City of Portland, Maine – Building or Use Permit Application 389 Congress Street, 04101, Tel: (207) 874-8703, FAX: 874-8716

Location of Construction: 71A, 71B, 73 (LOT 11) MAGGIE LANE (LOT 11)		Owner: ***** CUSTOM BUILT HOMES OF MAINE		Phone: 892-3149 ****	Permit No: 010034
Owner Address: 27 MAIN ST WINDHAM ME		Lessee/Buyer's Name:		Phone:	
Contractor Name: SAA		Address:		Phone:	
Past Use: 3XXXXXX VACANT	Proposed Use: NEW 3 UNIT TOWN HOUSE	COST OF WORK: \$ 190,000		PERMIT FEE: \$ 1164.00	
Proposed Project Description: NEW 3 UNIT TOWN HOUSE SINGLE FAMILY STYLE 2 STORY		FIRE DEPT. <input checked="" type="checkbox"/> Approved <input type="checkbox"/> Denied		INSPECTION: <i>multi-5</i> Use Group <i>R-3</i> Type: <i>53</i>	
		Signature: <i>[Signature]</i>		Signature: <i>[Signature]</i>	
Permit Taken By: K		Date Applied For: NOV 21 2000		PEDESTRIAN ACTIVITIES DISTRICT (P.A.D.)	
		Action: <input type="checkbox"/> Approved <input type="checkbox"/> Approved with Conditions <input type="checkbox"/> Denied		Signature: _____ Date: _____

**CITY OF PORTLAND, ME
BOCA 1999 Plan Review Record
One and Two Family Dwelling**

REASON FOR PERMIT: To Construct a new 3 unit Town House (multi Single Fami

Drawing Name: <b>Space &amp; Bulk Requirements Lot 11</b>
Project: <b>MAGGIE LANE, PORTLAND</b>

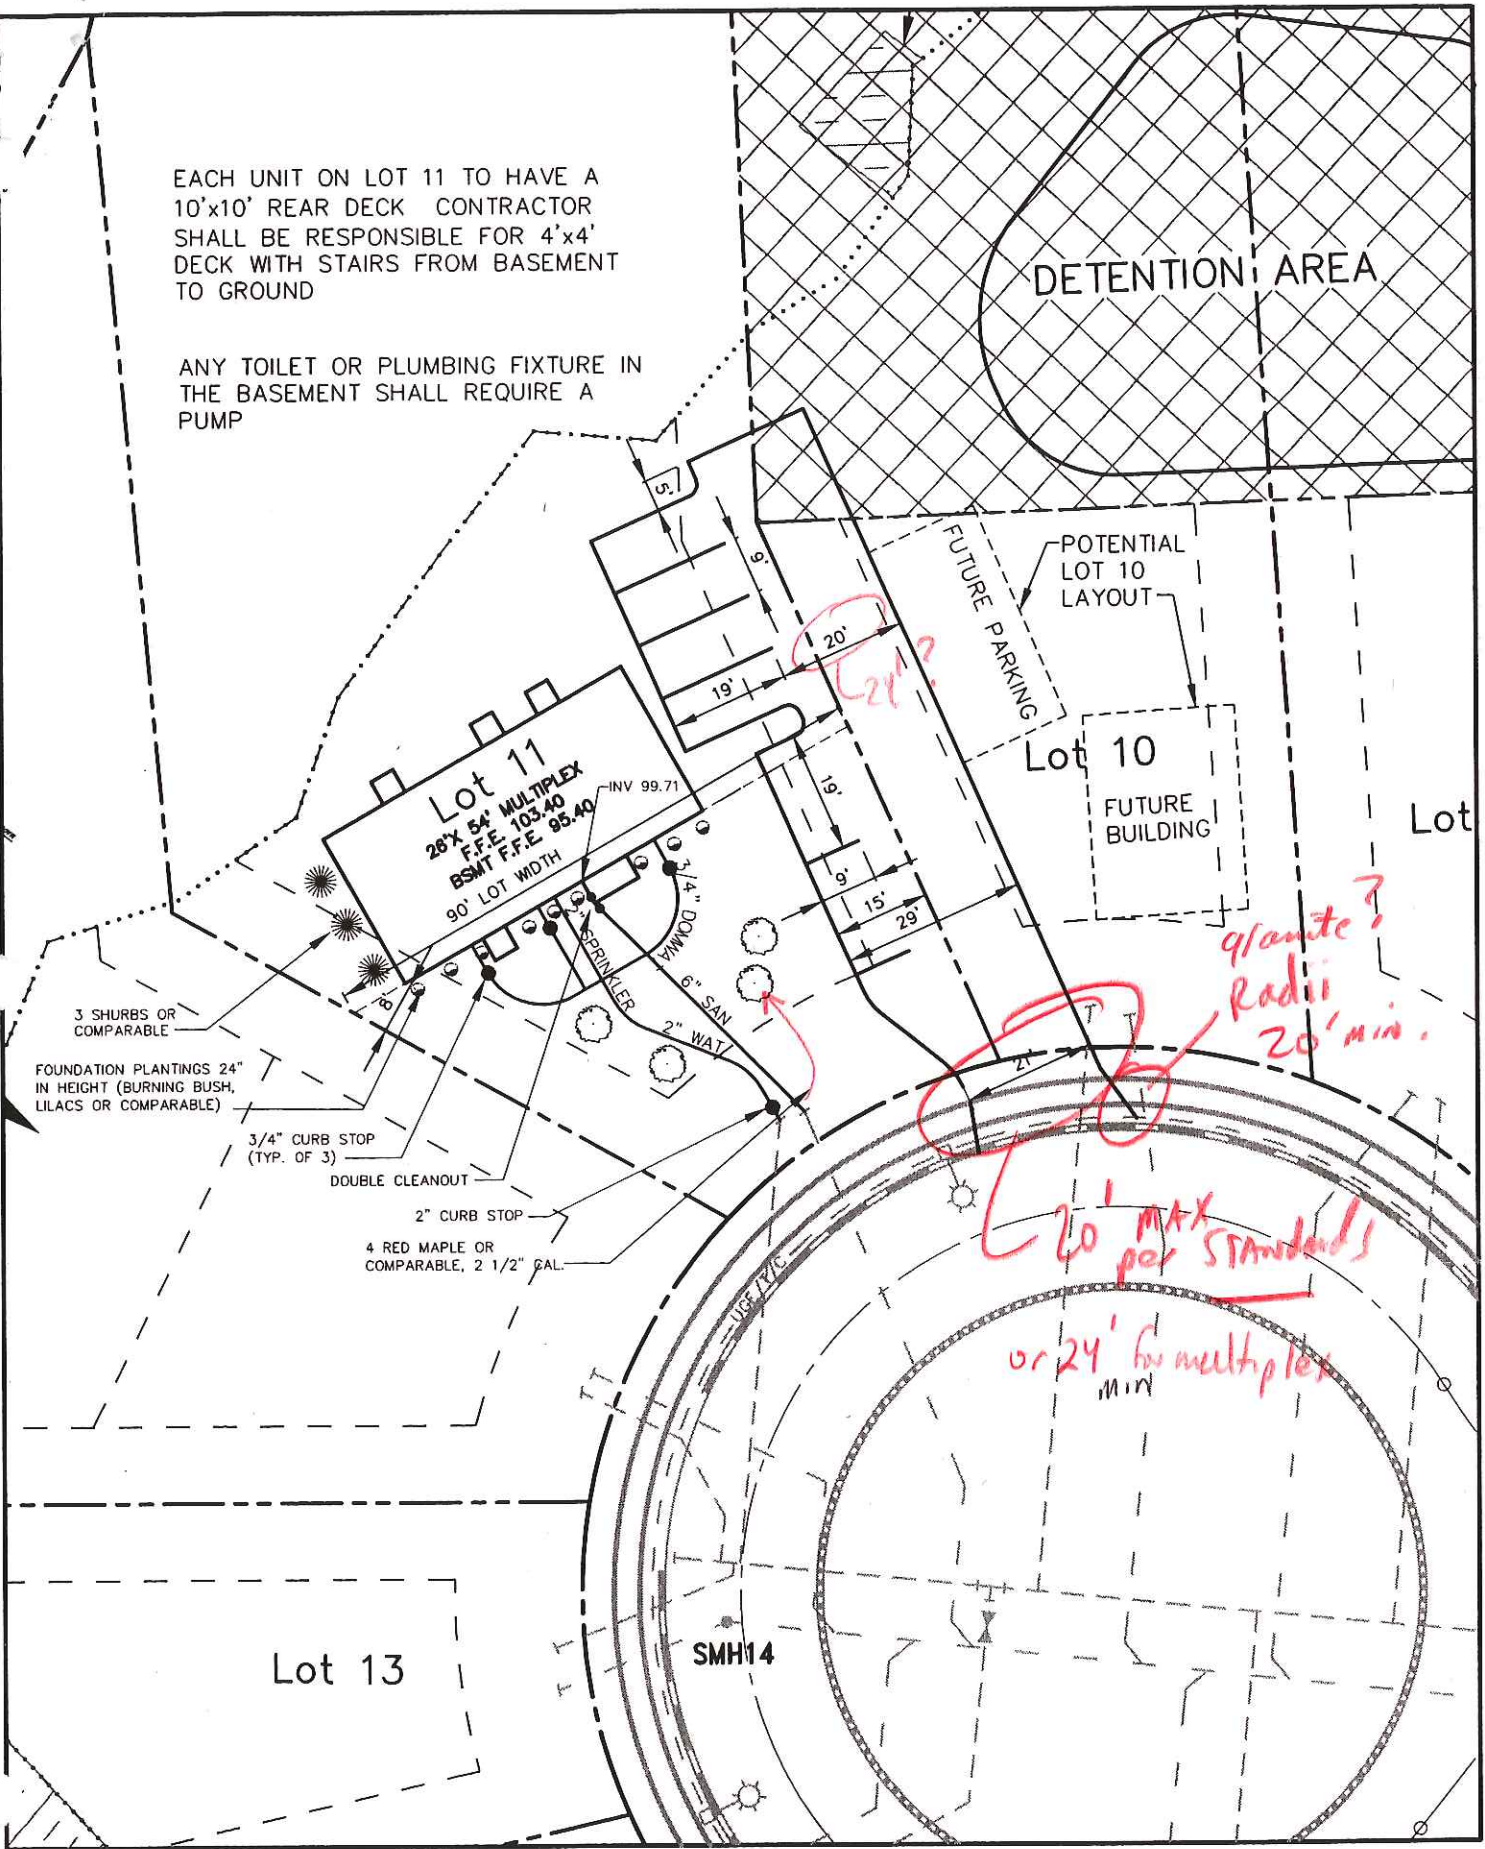
Projections - front porch slabs - rear 10'x10' decks - NO stairs from decks Allowed

Drawing Name: **Layout & Utilities - Lot 11**  
 Project: **MAGGIE LANE, PORTLAND**

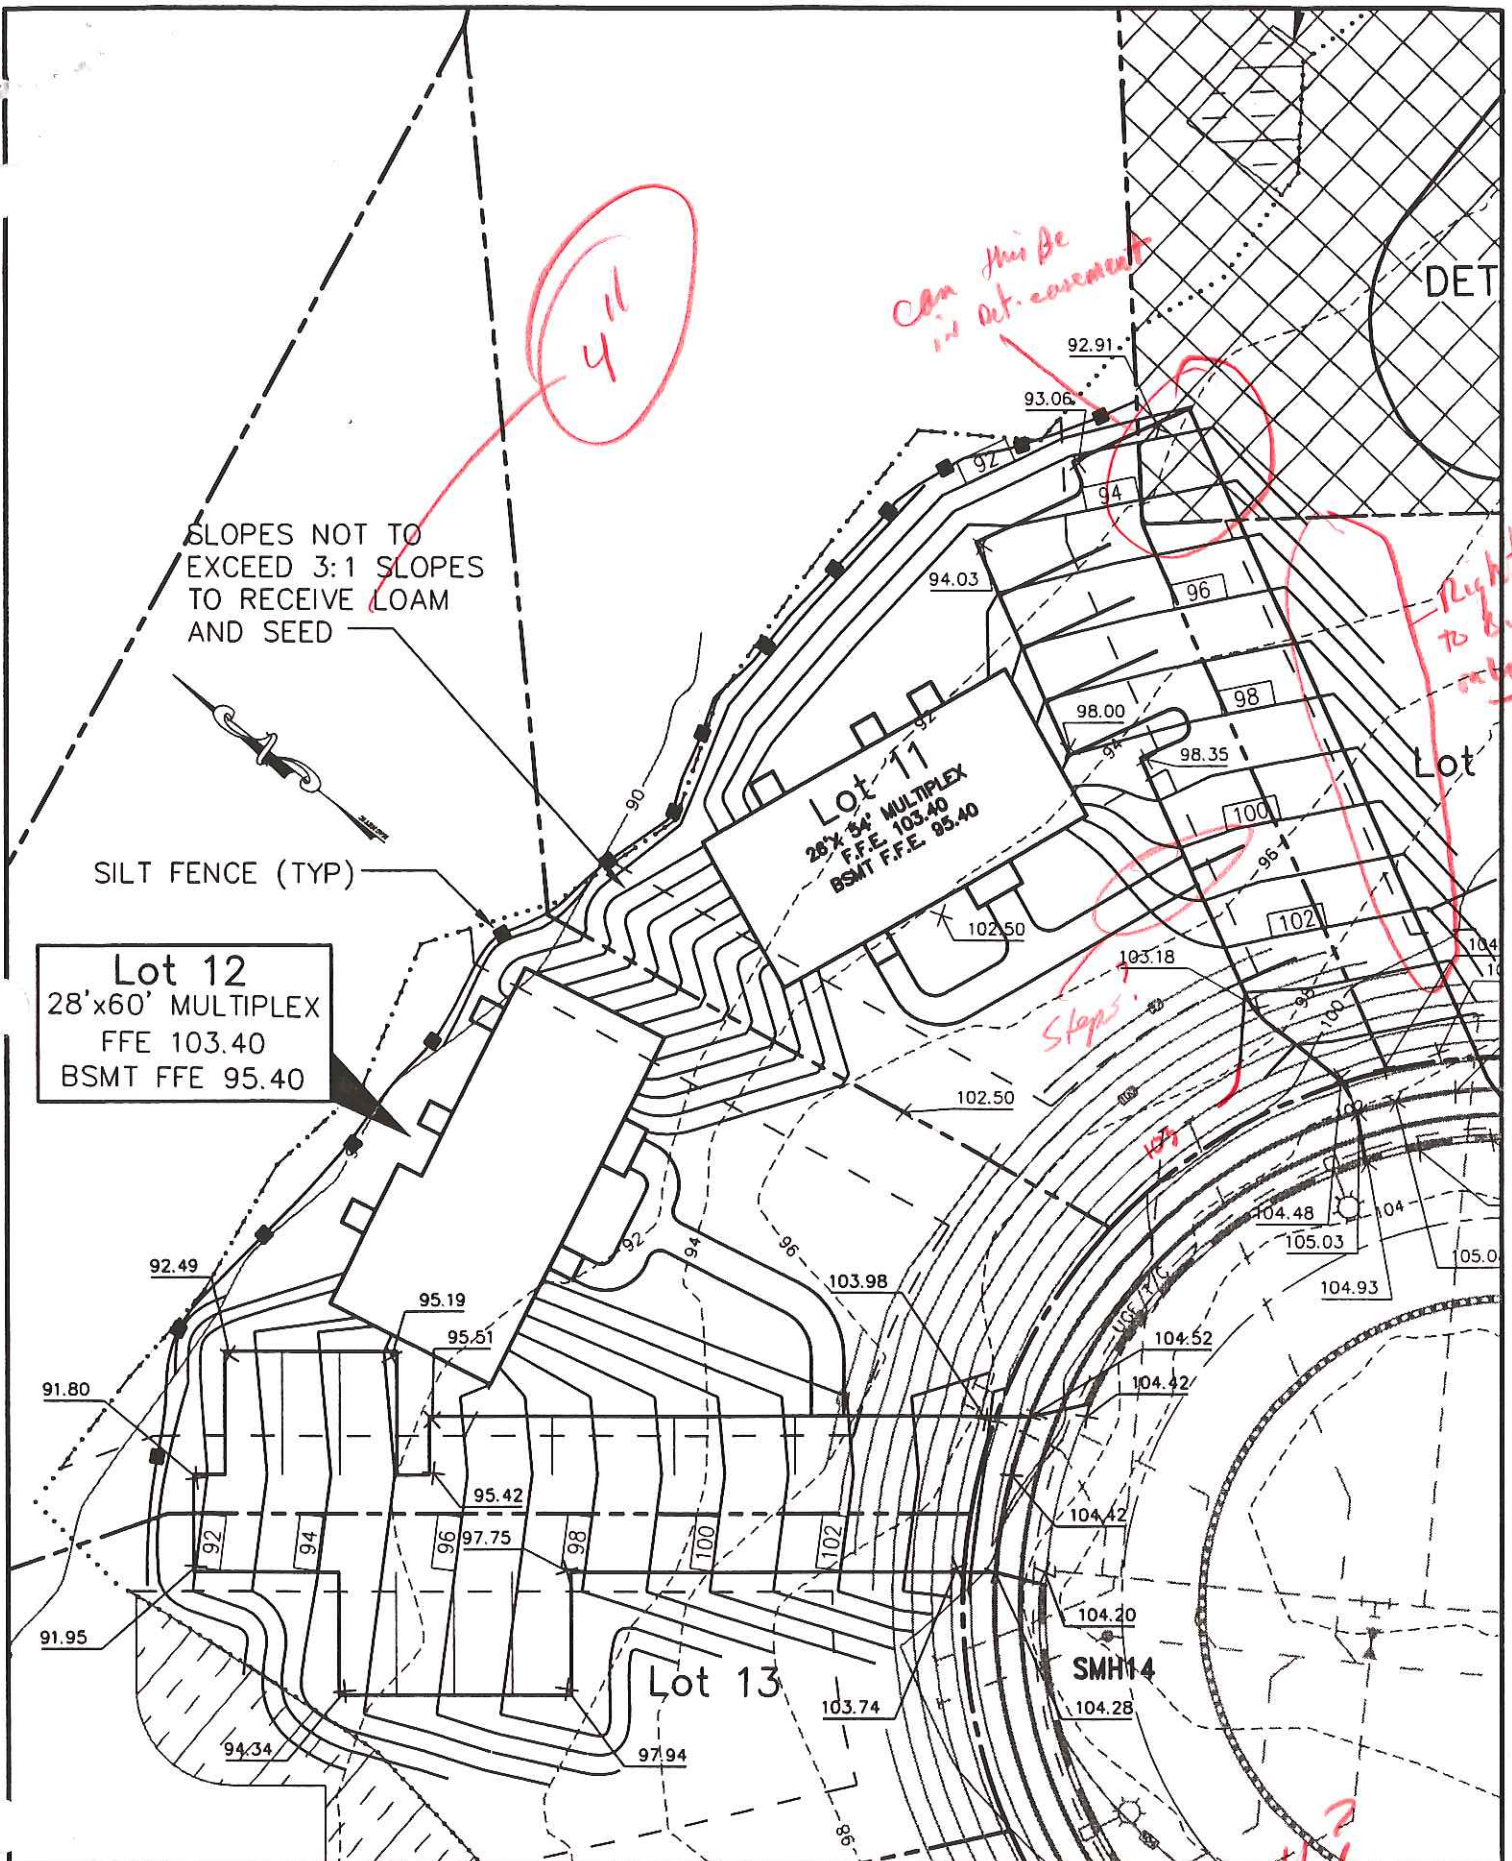
Show all utility connections: water, sanitary, sewer, storm drain, electric, telephone, cable.

A drainage plan shall be submitted to and approved by Development Review Coordinator showing first floor elevation (FFE), sill elevation (SE), finish street/curb elevation, lot grading, existing and proposed contours, drainage patterns and paths, drainage swales, grades at or near abutting property lines, erosion control devices and locations and outlets for drainage from the property.
